OXFORDSHIRE COUNTY COUNCIL'S RESPONSE TO CONSULTATION ON THE FOLLOWING DEVELOPMENT PROPOSAL

Application no: 22/01682/F

Proposal: Development of a ground mounted solar farm incorporating the installation of solar PV panels, associated infrastructure and access, as well as landscape planting and designated ecological enhancement areas

Location: Land North Of Manor Farm, Noke

Name	Date	Remarks	Revision
HG	10-05-23	UPDATE TO ATTENUATION OPTION ANNOTATION	P06
GS	10-01-23	UPDATE TO ATTENUATION OPTION	P05
GS	14-09-22	UPDATE TO ADD ATTENUATION OPTION	P04
AG	15-11-21	UPDATED LAYOUT	P03
HG	13-10-21	SURFACE WATER DRAWING	P02
DH	08-02-21	SURFACE WATER DRAWING	P01

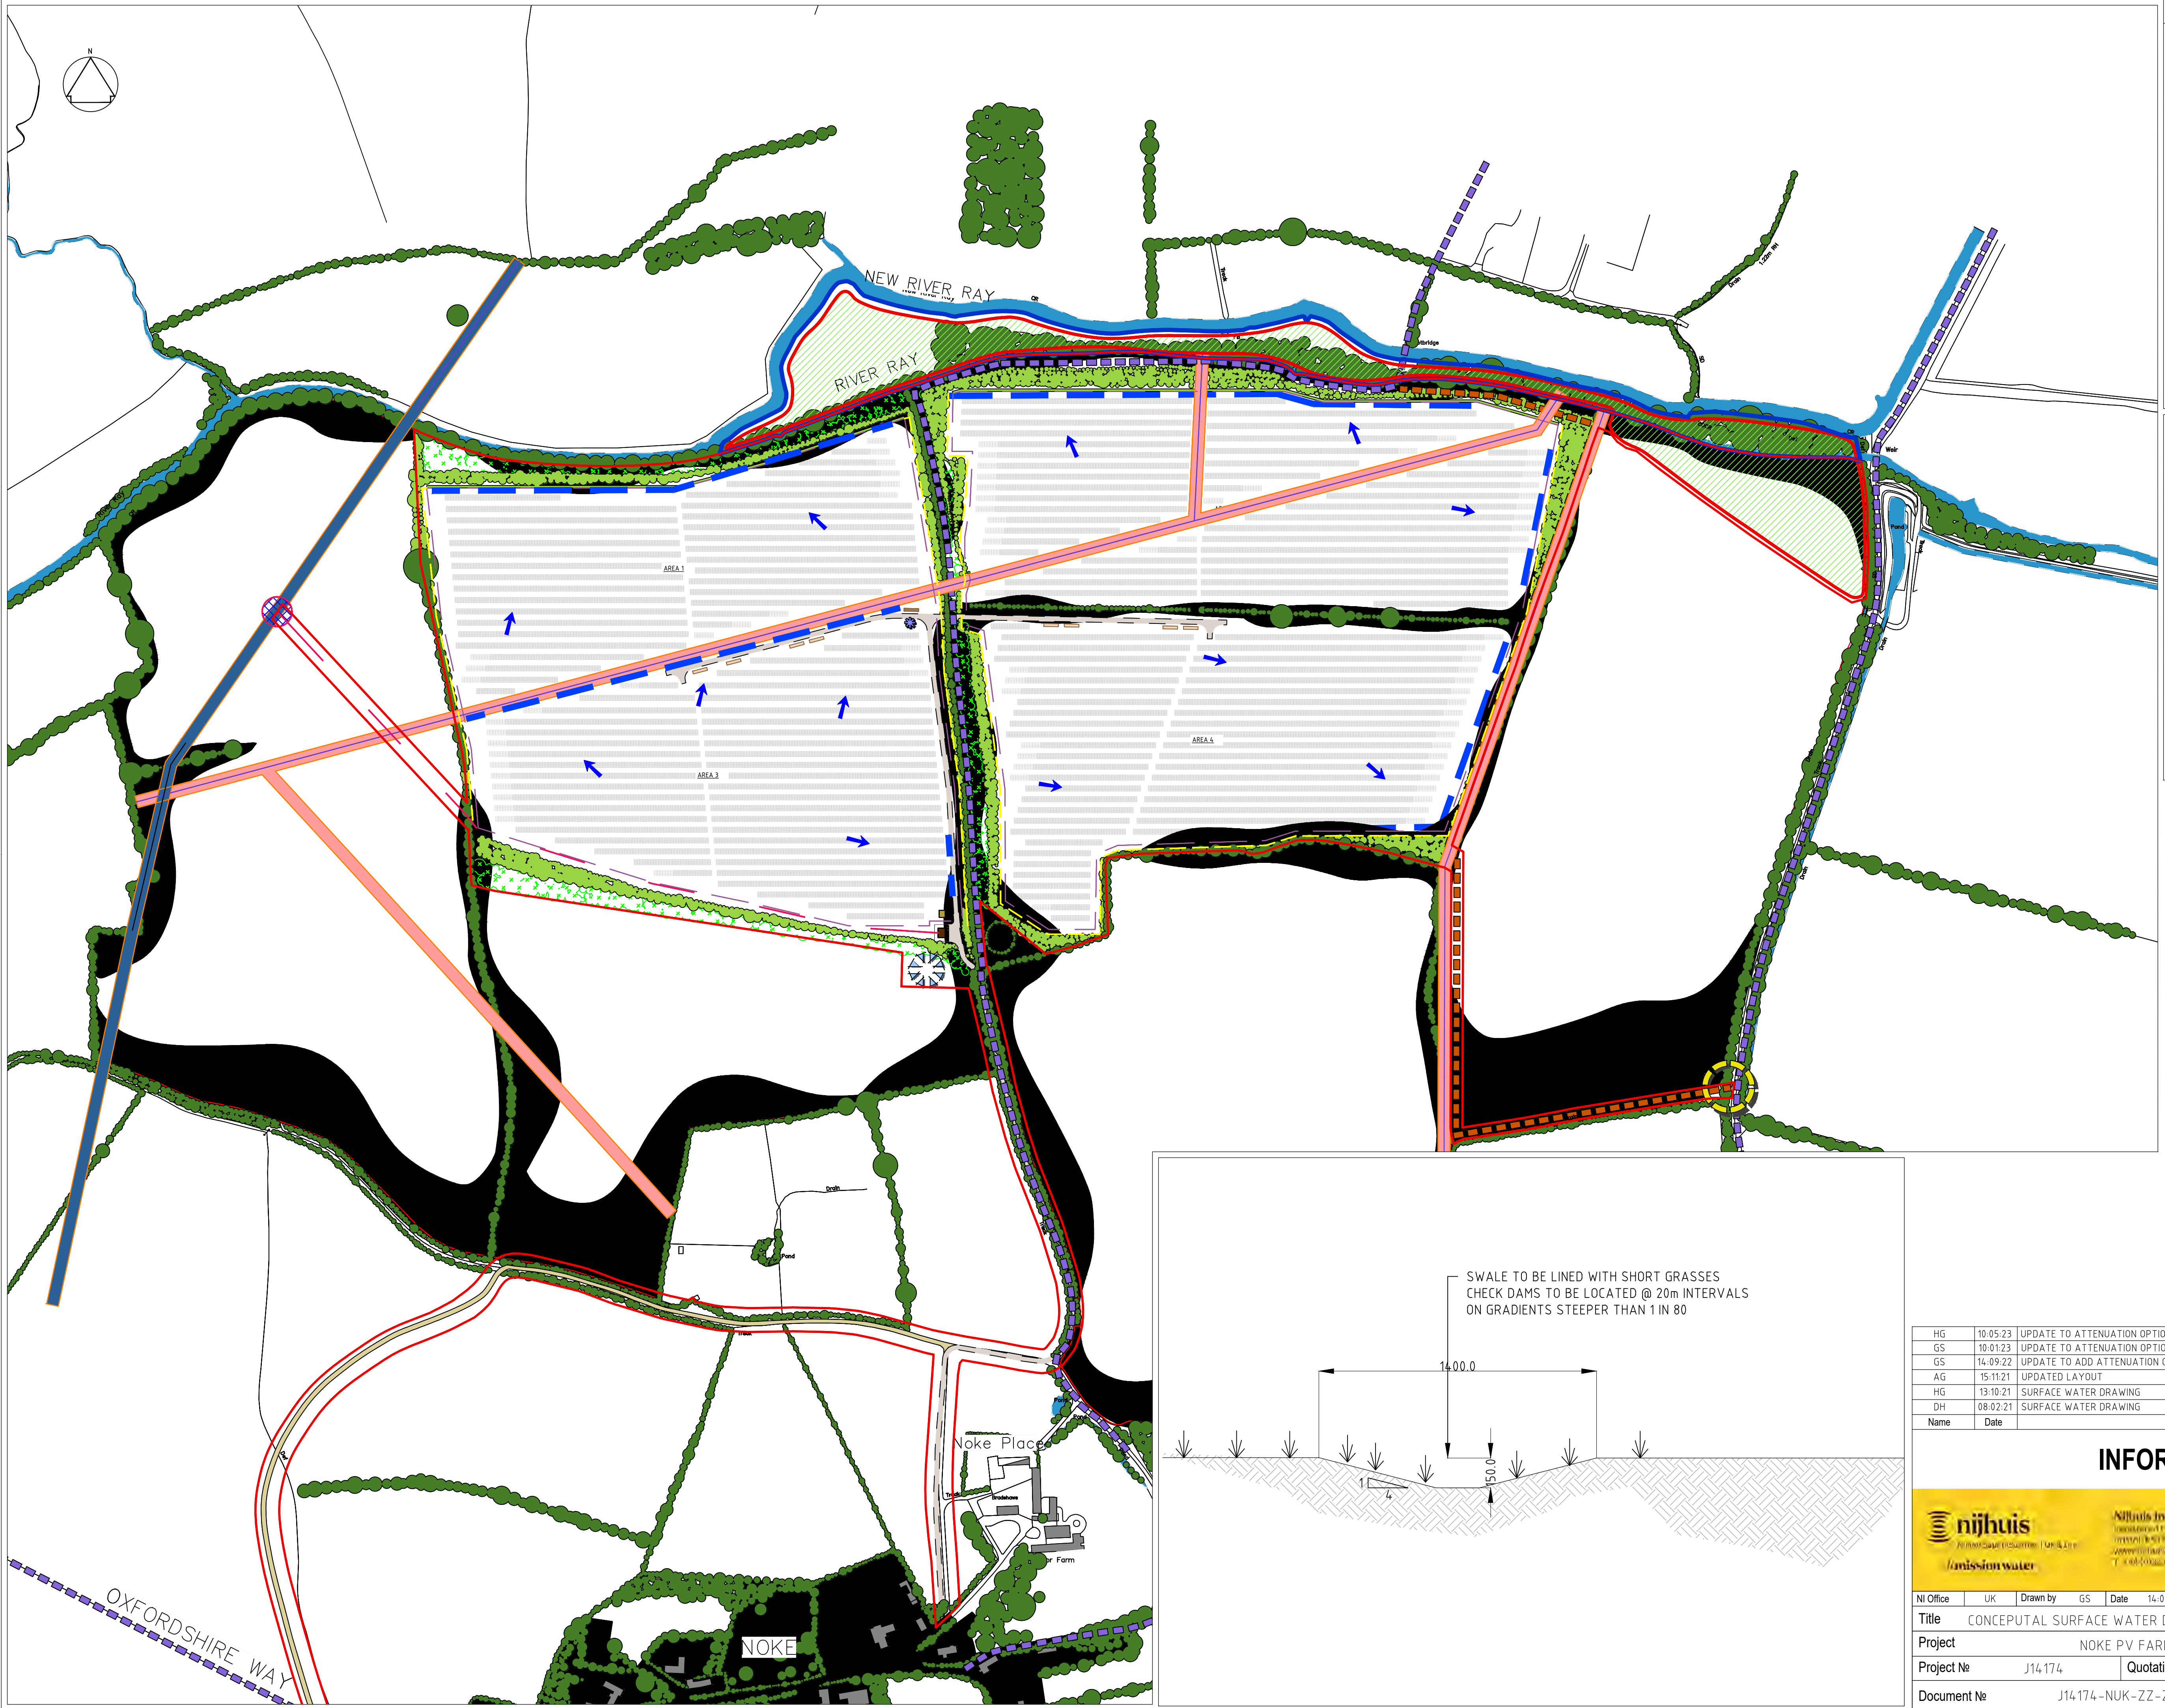
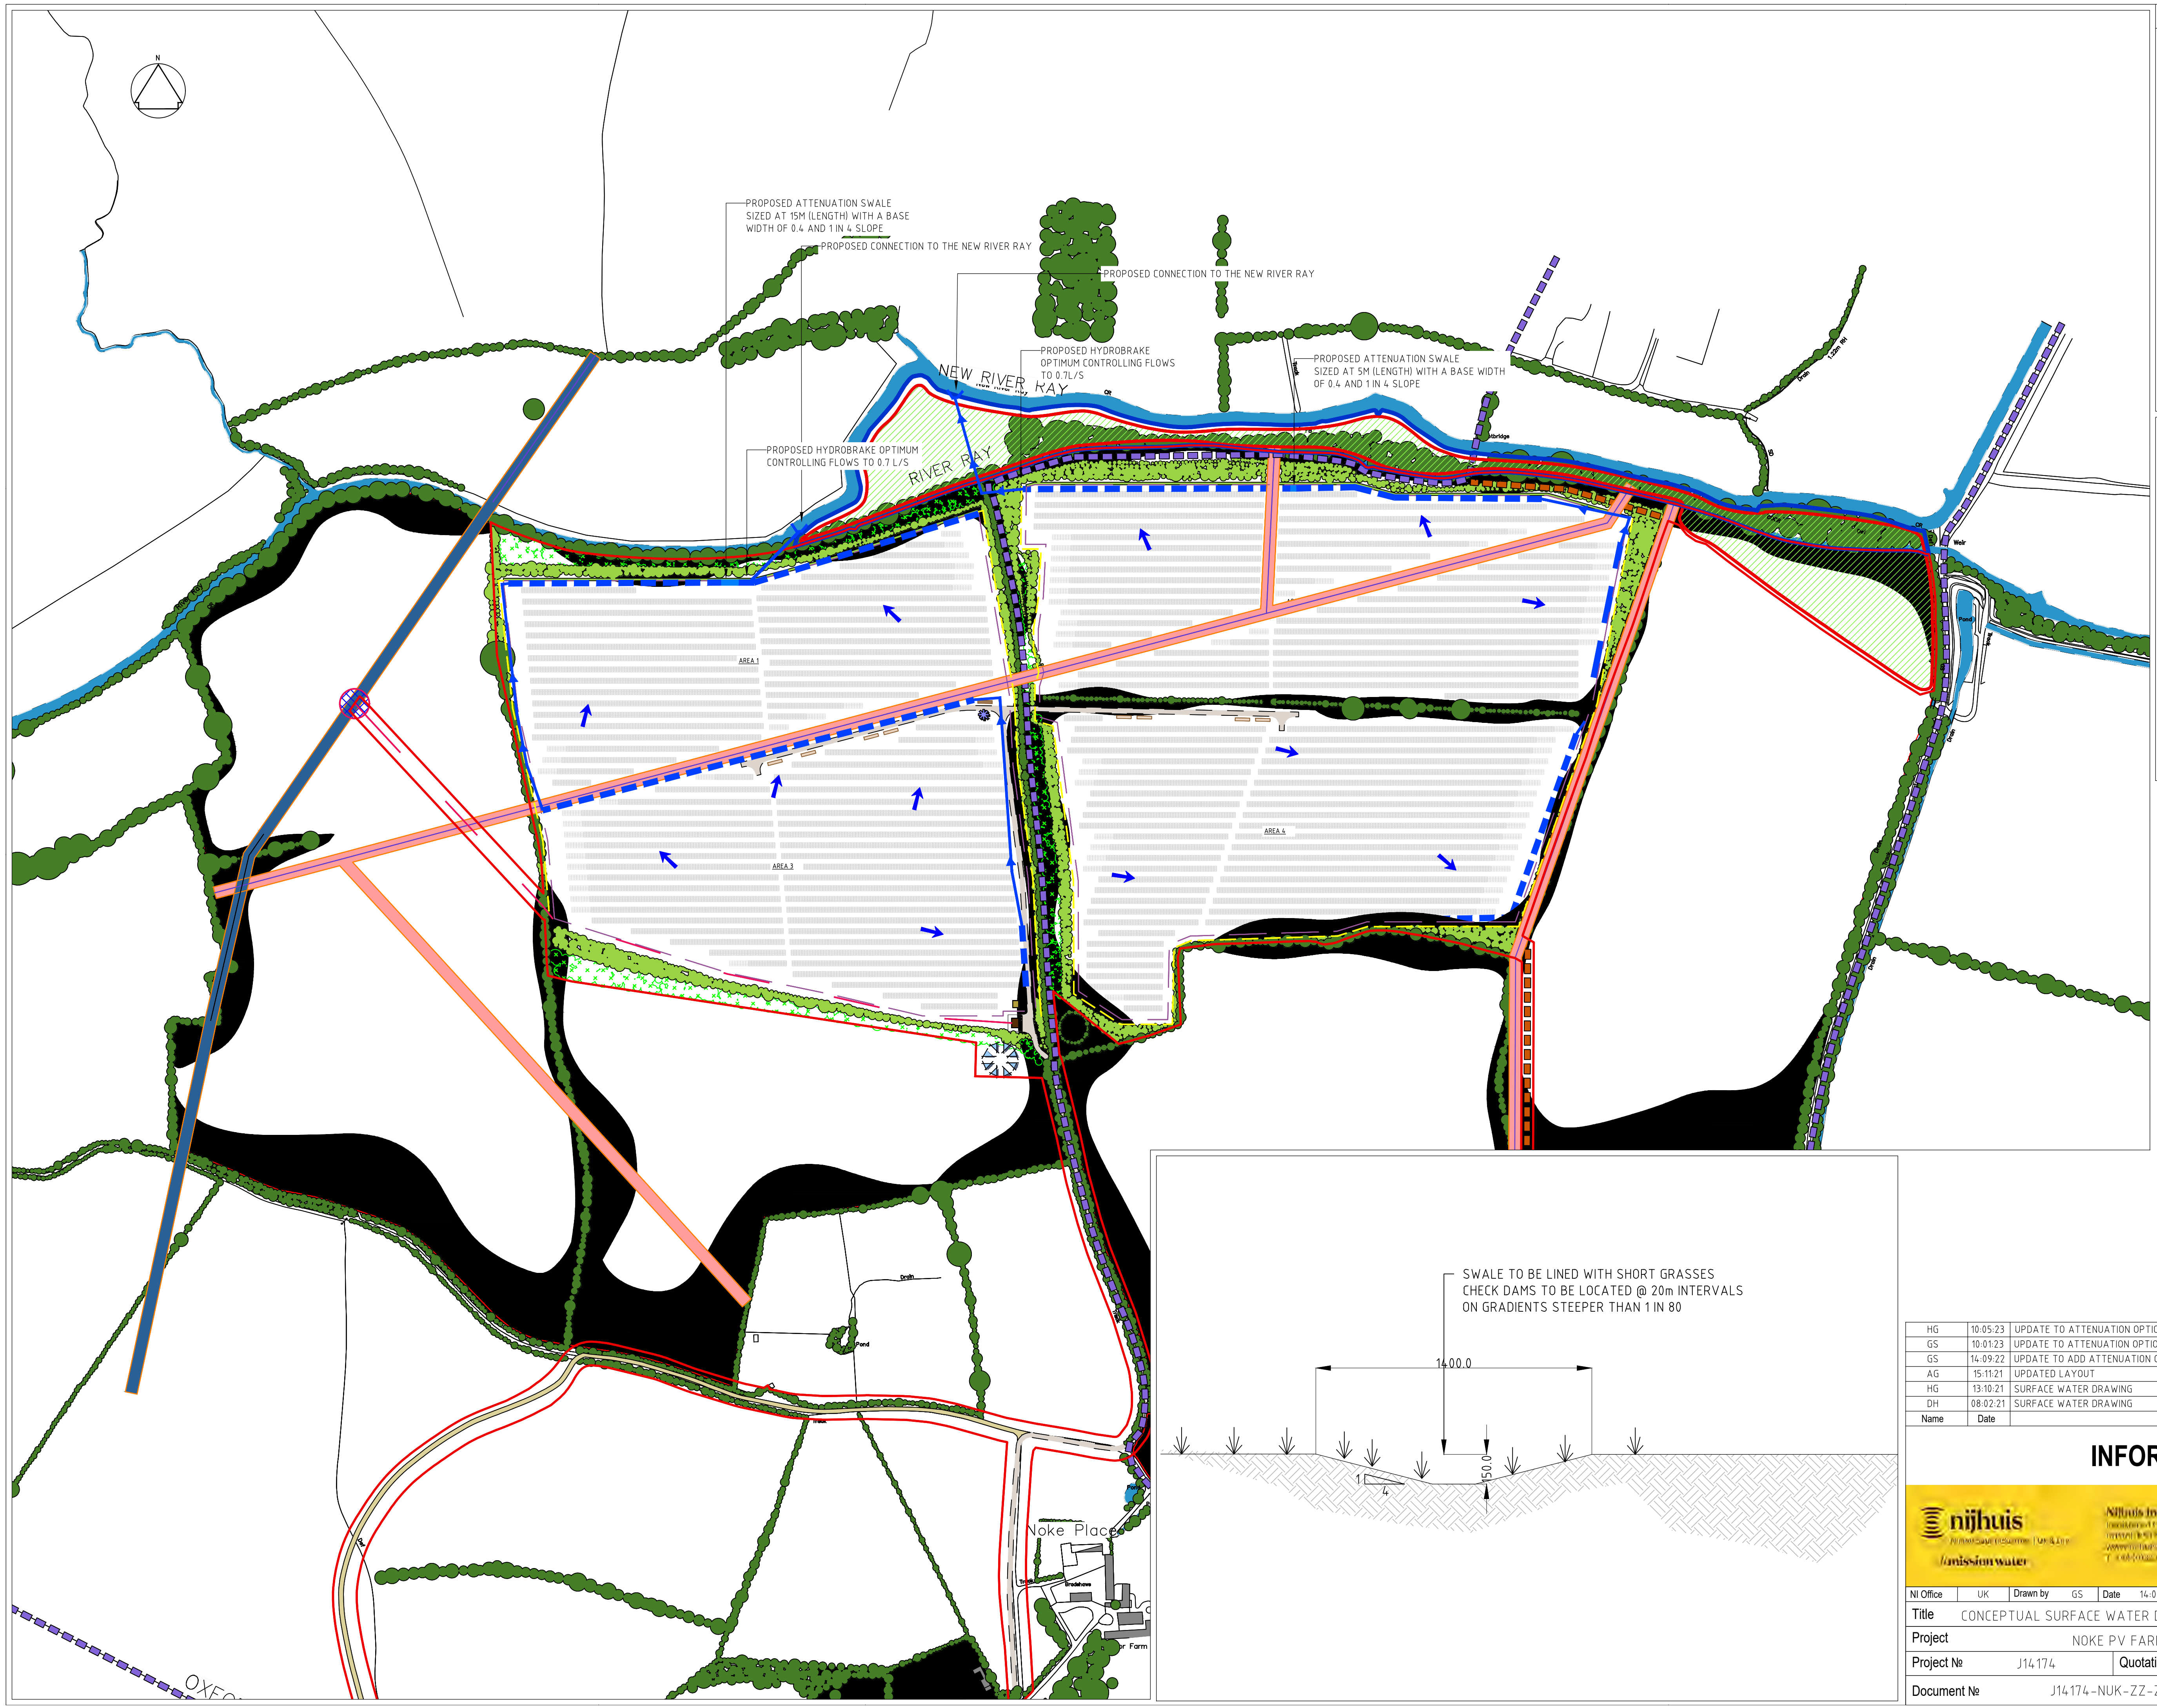
The amended flood risk assessment has been reviewed and the previous LLFA comments has not been addressed.

- Discharge rates to be based on Qbar greenfield run off rate.
- Provide updated drainage strategy drawing showing all the discharge rates based on Qbar greenfield run off rate.
